Response to Planning application from Hertfordshire County Council (T and CP GDP Order 2015)

District ref: 6/2022/1106/FULL
HCC ref: WH/12320/2022
HCC received: 2 August 2023
Area manager: Manjinder Sehmi
Case officer: Senober Khan

1 LONGCROFT GREEN WELWYN GARDEN CITY AL8 6EP

Erection of 1 x detached 4 bedroom dwelling and detached 3 and a half storey building accommodating 6 no flats (4 x 2 bedroom and 2 x 3 bedroom flats), car parking, refuse and recycling bins enclosure, secure cycle storage, turning heads and use of the existing vehicular access following the demolition and removal of a pair of semi-detached dwellings

**Apartment Block
Proposed Layout Plans
Ground & First Floor**

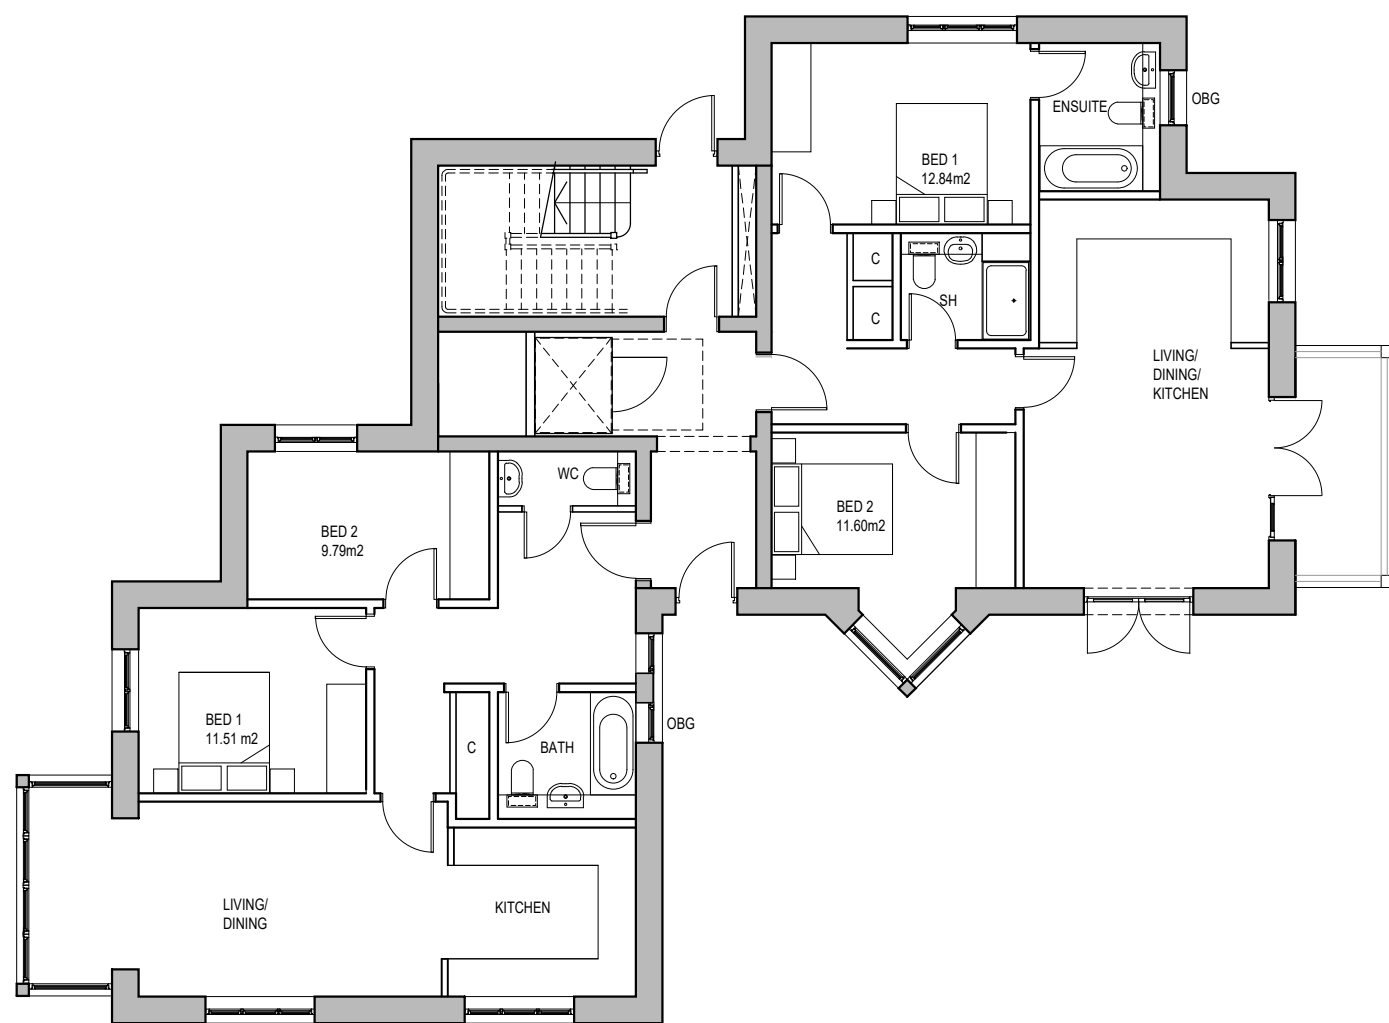
It would appear from the submitted plan that the applicant is proposing a 14 space two-tier cycle store. Two tier cycle parking facility is only suitable for non-residential developments because it is less convenient than Sheffield type stands and discriminatory for short people and those with low strength. People with mobility issues are also disadvantaged due to the difficulties involved with lifting at height. Additionally, limited types of cycles can fit within double deck systems in comparison with the Sheffield type stand eg shopping baskets, child seats, etc. This is a residential development and so the cycle parking should be of the type accessible by all users. Furthermore, the applicant will be required to demonstrate in detail how the cycle store complies with the HCC/manufacturers specifications.

The car parking bay next to the cycle store should be offset by an additional 0.5m, to enable car doors on both sides of the vehicle to be accessible.
